Addendum 1: Allegro Acoustics Response to TII Comments from Metrolink Hearing - Module 1

Prepared By: Dirun Ergin & Stephen Kearney

Date: 20th of March 2024

Drawing Title  
**Figure 14.2 Groundborne Noise from Tunnel Boring Machine**  
Sheet 1 of 7

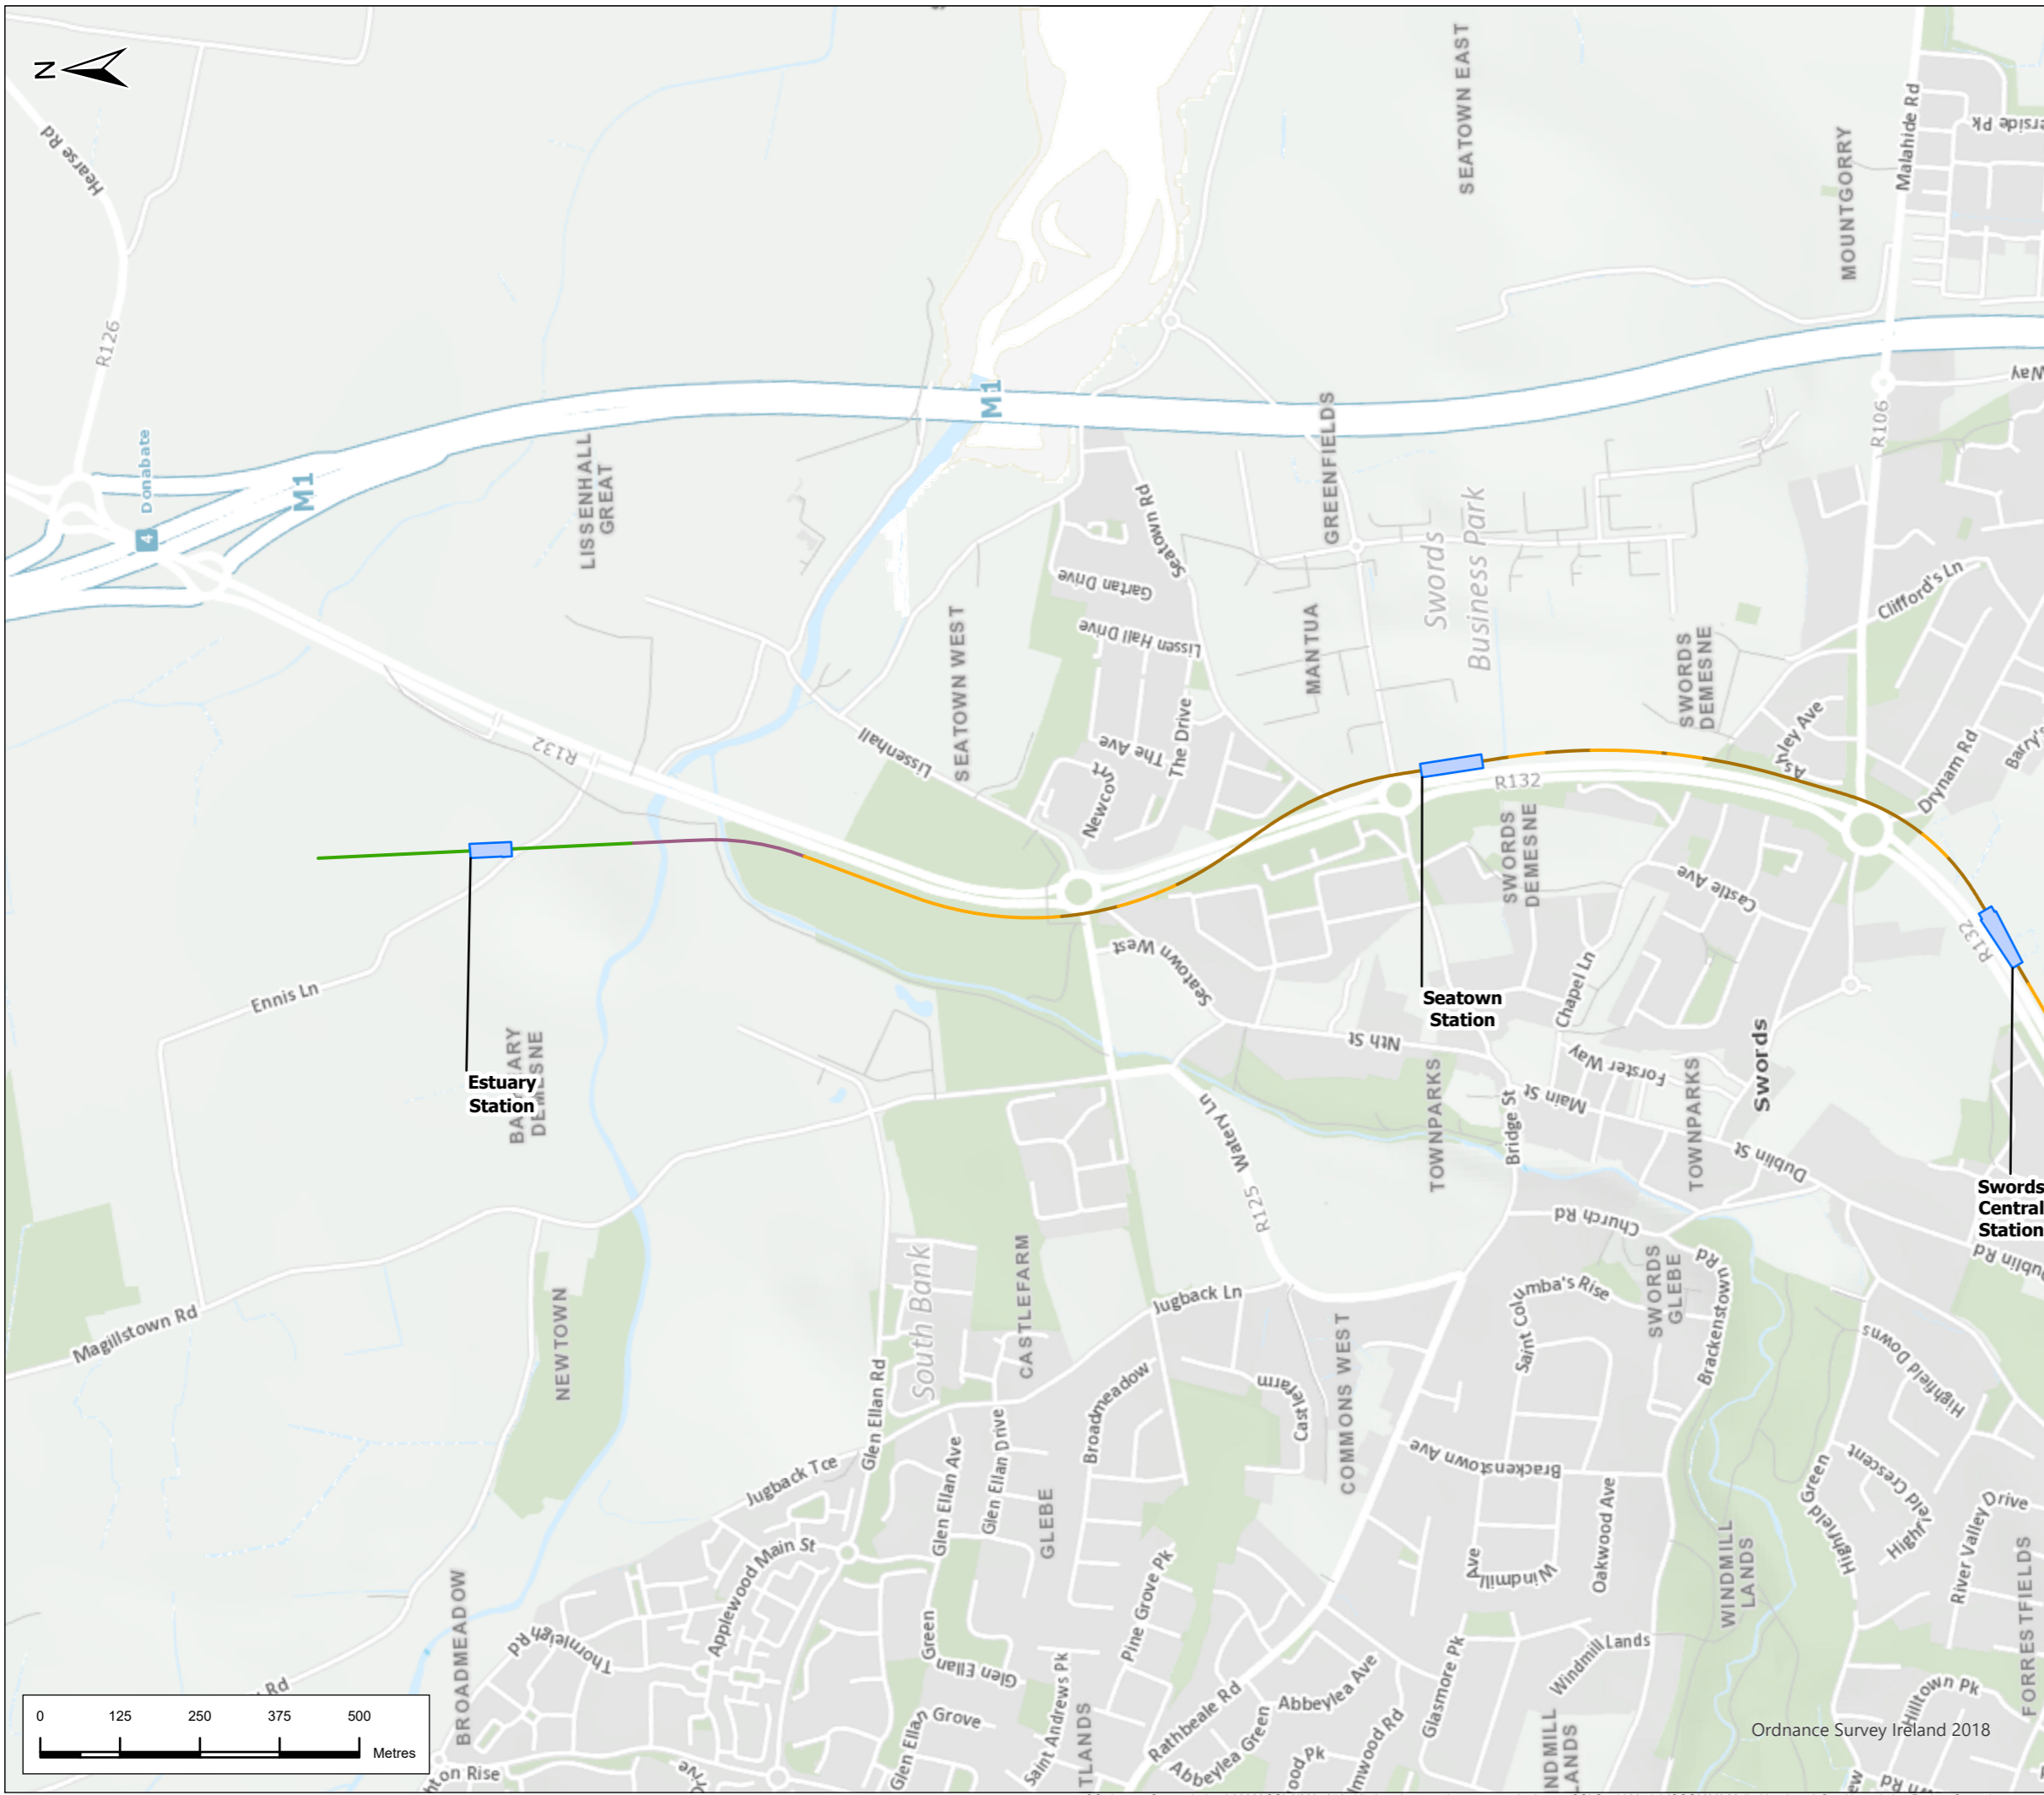
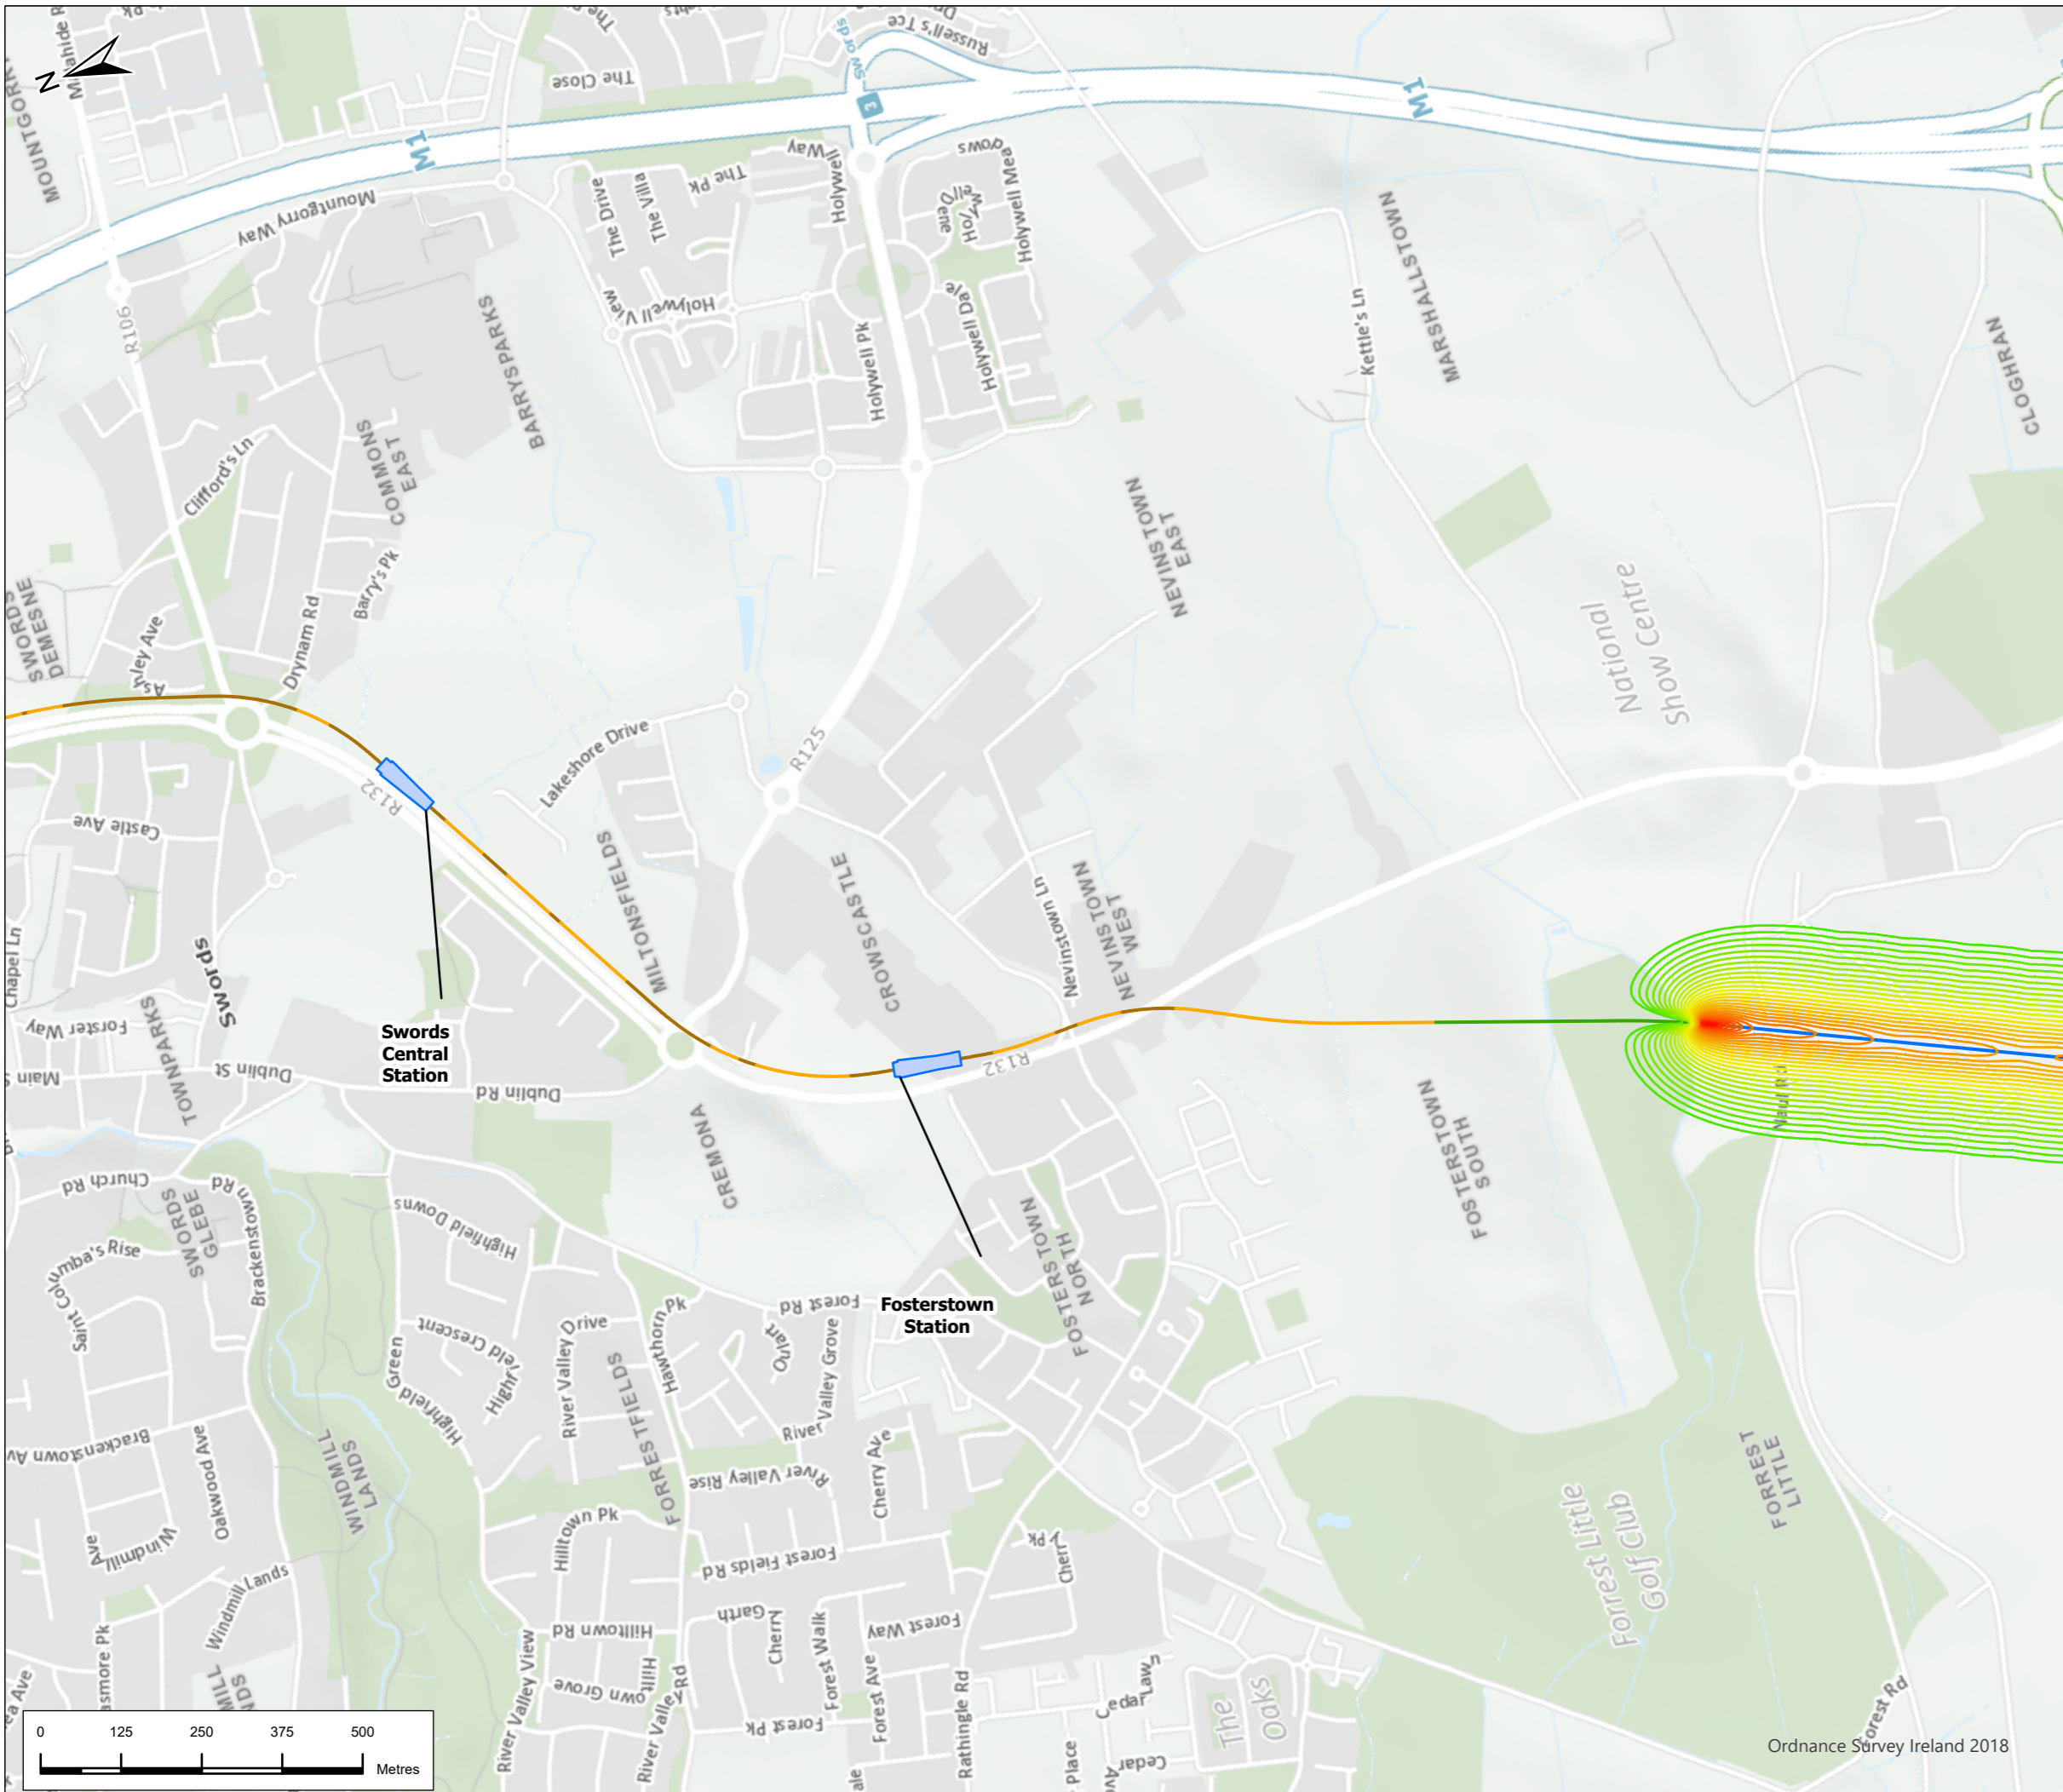
Allegro Acoustics understands the comment above to mean that the only source of construction stage ground borne noise at the Cadenza Building will be noise from the Tunnel Boring Machine. Can TII confirm that this interpretation is correct?

Allegro Acoustics notes that the predicted construction stage noise level of 50dB $L_{Amax,s}$ while the Tunnel Boring Machine is in operation is above the 45dB $L_{Amax,s}$ construction stage threshold outlined by the TII in EIAR Table 14.3. A level of 45dB $L_{Amax,s}$ is noted in this table to be *Noticeable to all and disturbing to some*.

It is therefore considered likely that the predicted construction stage noise level of 50dB $L_{Amax,s}$ is likely to cause disruption to users of the Cadenza Building while the Tunnel Boring Machine is in operation in the vicinity of the building.

Allegro Acoustics Response: As per Allegro Acoustics response to Comment 1 above, it is noted that the predicted construction stage noise level of 50dB $L_{Amax,s}$ is likely to cause disruption to users of the Cadenza Building while the Tunnel Boring Machine is in operation in the vicinity of the building.
